Gatwick Airport Northern Runway Project

Examination Ref: TR020005

Joint Local Authorities' Response to the Applicant's Deadline 8 Submissions

Deadline 9: 21 August 2024

Title:
Ordnance Survey Base Map Identifying Category 3 and Noise Insulation Scheme Boundary - Sheet 1 of 4

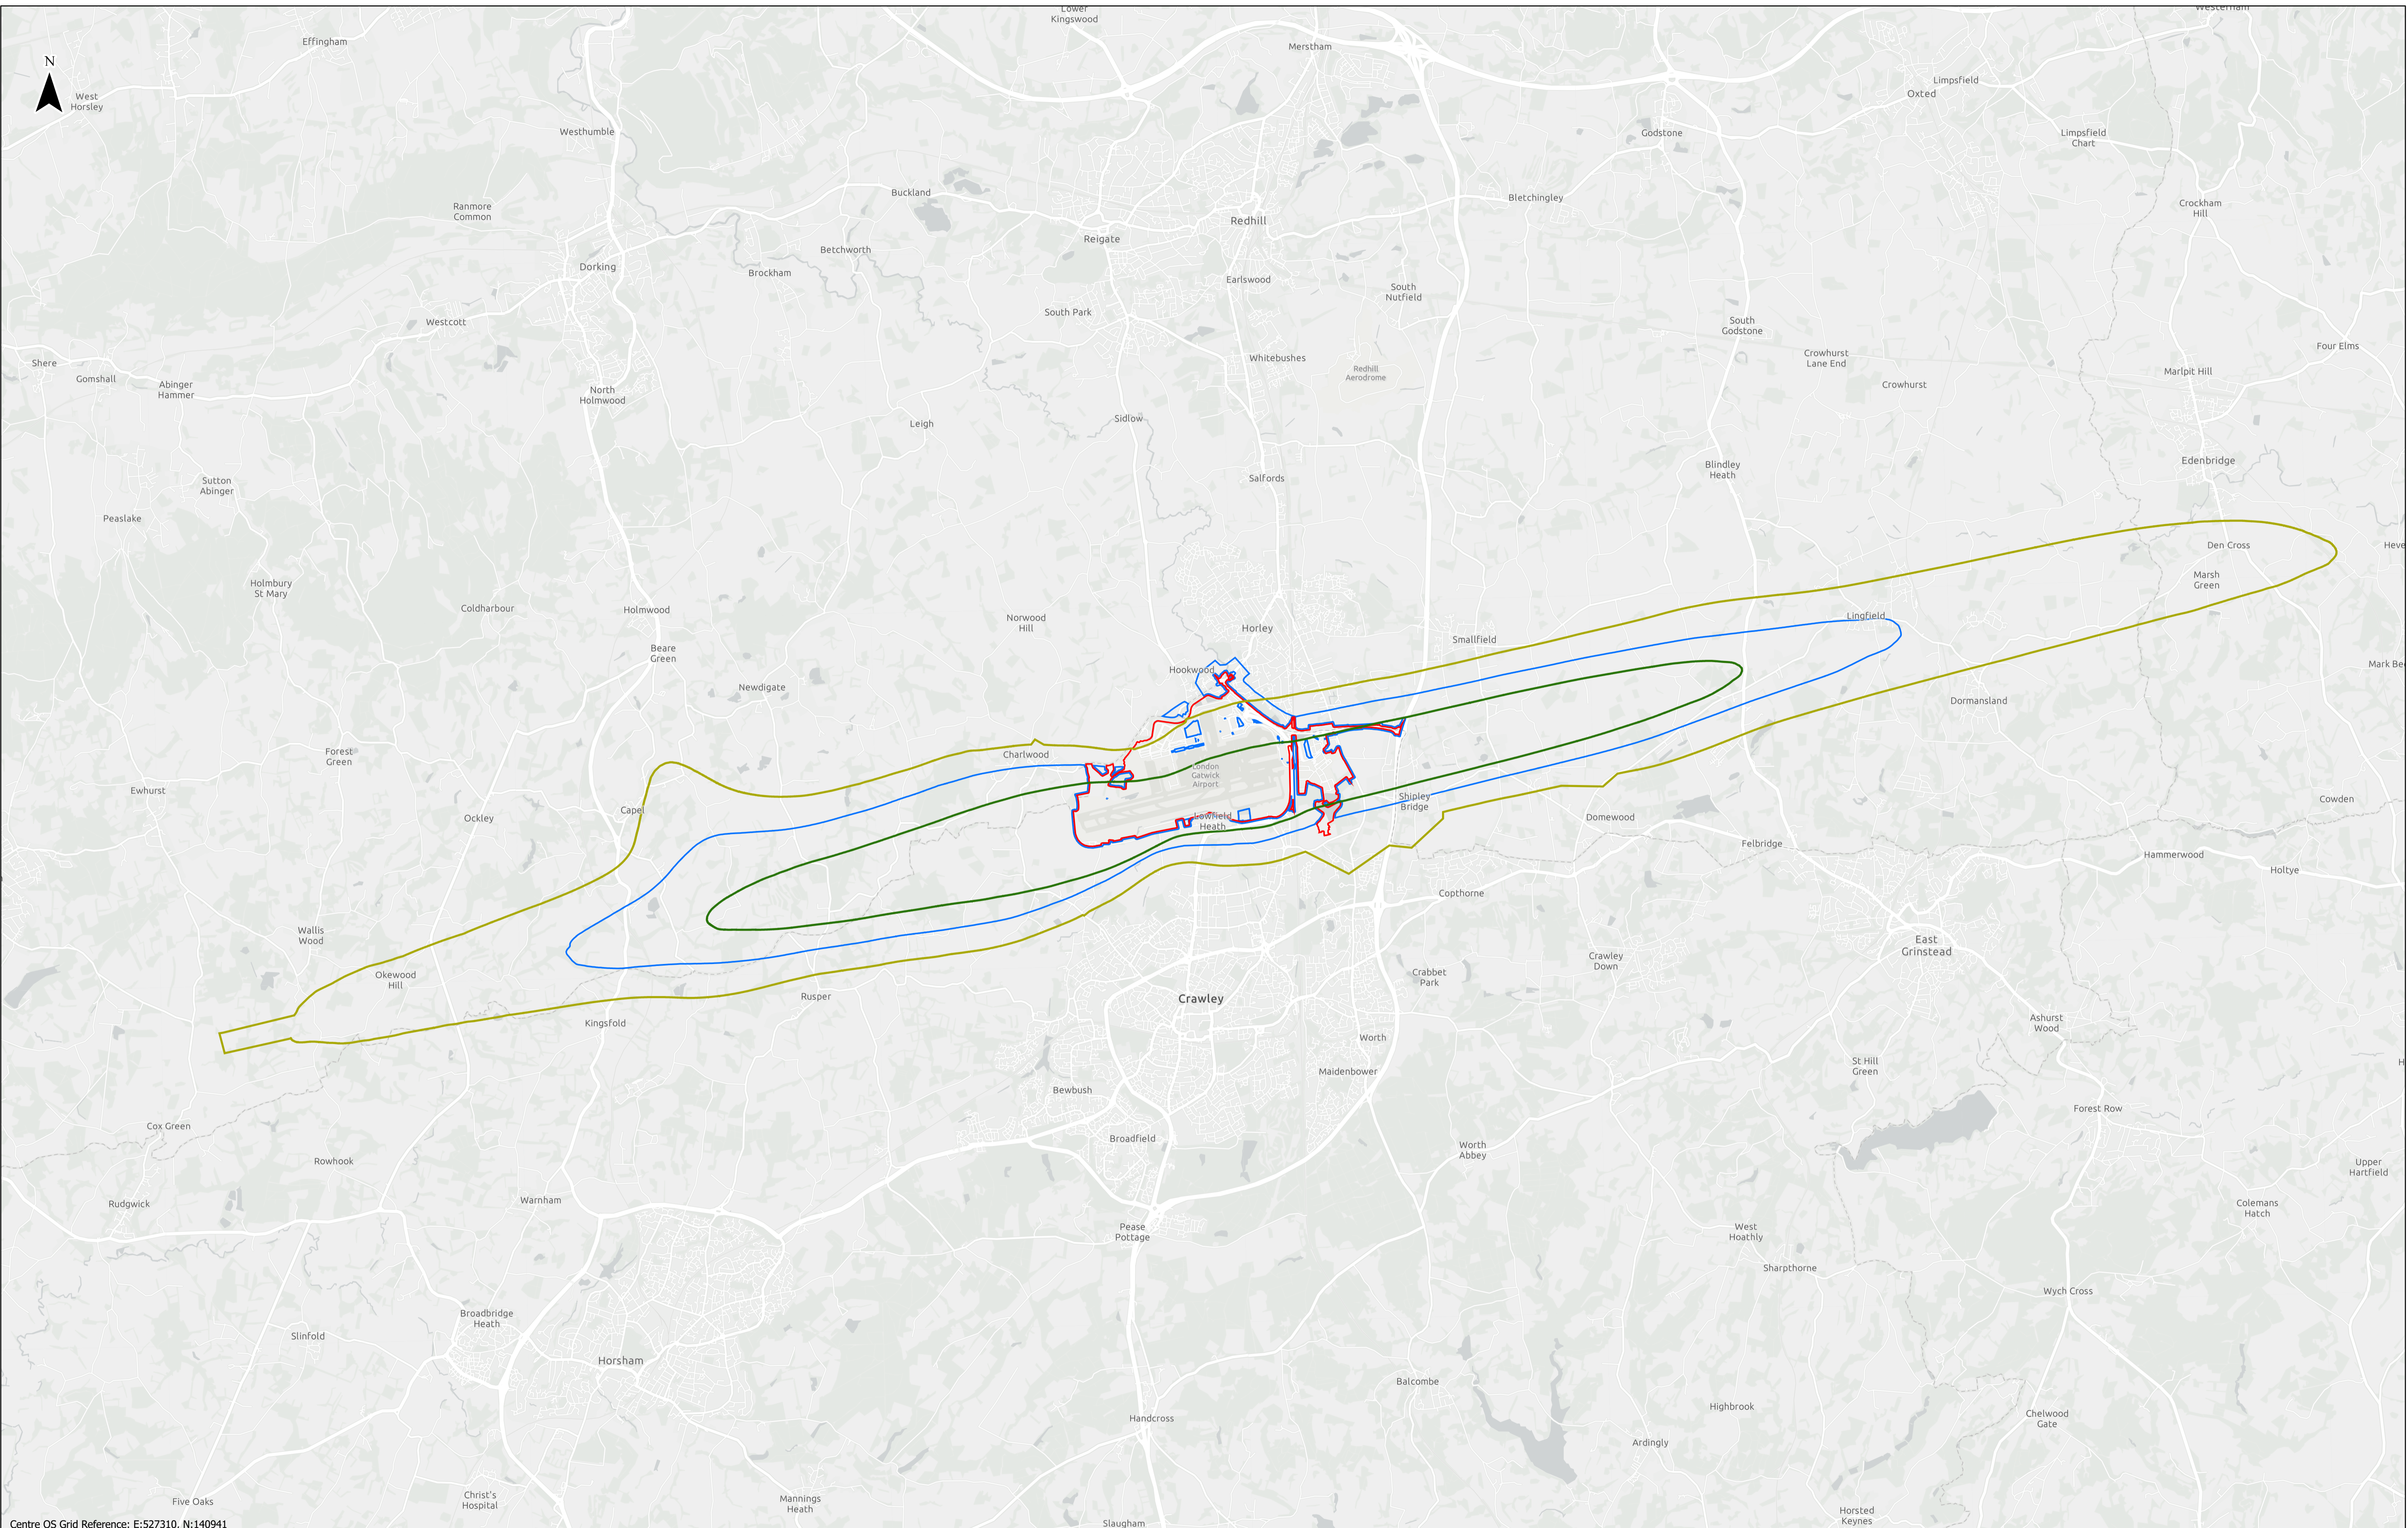
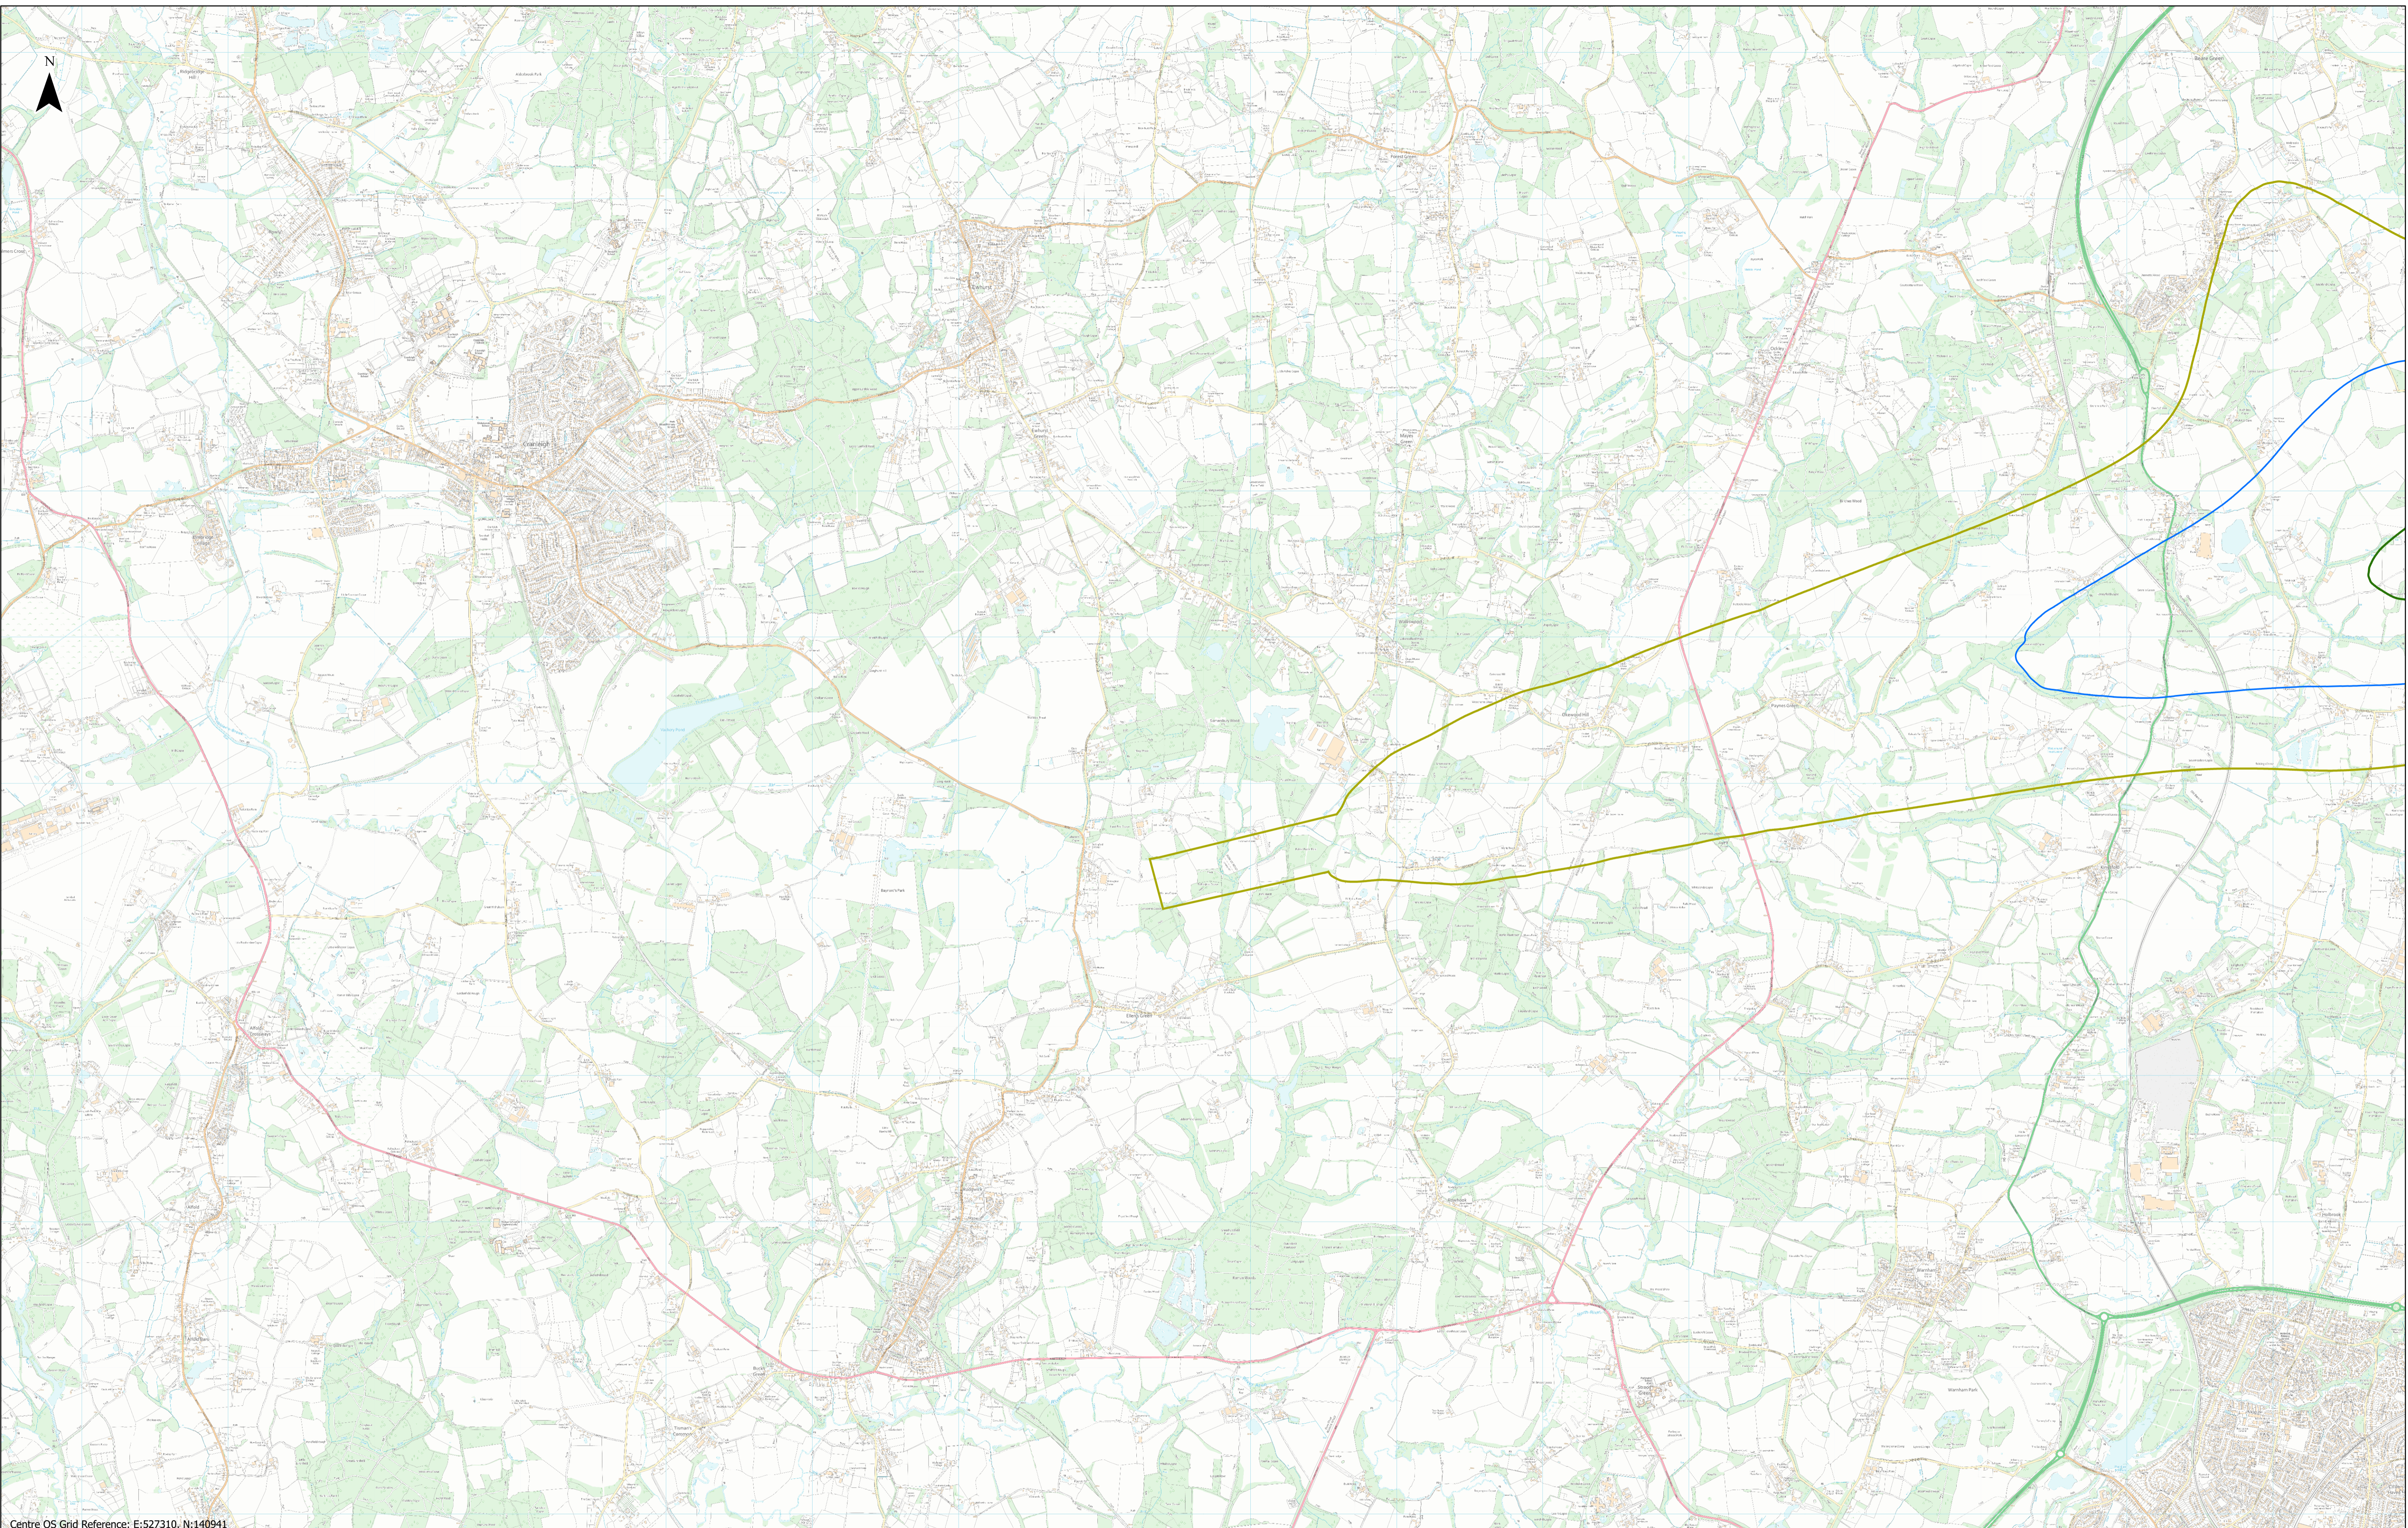
- 4.1 The Applicant has confirmed their proposals on the division of the outer zone, timings on delivery of the works, the use of the updated central case fleet and some minor further proposals for installation of thermal insulation in loft space.

- 4.2 The JLAs do not consider that the scheme satisfactorily addresses acoustics, ventilation and overheating and that harmful exposure to noise is likely to occur, as are other potential health effects and that the comments in [\[REP5-094\]](#) are still valid.

- 4.3 Importantly, any property qualifying for noise insulation must have an overheating assessment performed and an insulation scheme designed to ensure that there is an appropriate internal living environment.

- 4.4 The scheme takes no account of protecting those people who are within one additional noise induced awakening contour that the JLAs maintain is a significant observed adverse effect level and have discussed in some detail in [\[REP1-068\]](#),[\[REP1-100\]](#), [\[REP7-103\]](#), [\[REP8-161\]](#).

- 4.5 The one additional noise induced awakening contour should be treated as a primary metric and the Applicant still needs to provide full set of contours for this information and update the noise insulation scheme accordingly.

- 4.6 The scheme continues to operate on an average mode contour. The JLAs continue to believe that whilst this has some provenance given

the magnitude of effects on people living in the area and by reference to the Airports National Policy Statement para 5.68 it is reasonable to secure the noise insulation scheme on the basis of single mode contours.

- 4.7 The scheme inadequately assesses and make provision for dealing with the effects of ground noise between SOAEL and LOAEL and the cumulative impacts of air and ground noise on a predictive basis.
- 4.8 The JLAs welcome the proposals by the Examining Authority to consider cumulative and individual impacts of air and ground noise to the thresholds proposed. The JLAs cordially request that the Examining Authority reviews their position and includes the one additional noise induced awakening within their proposed scheme to ensure that all effects are properly addressed.
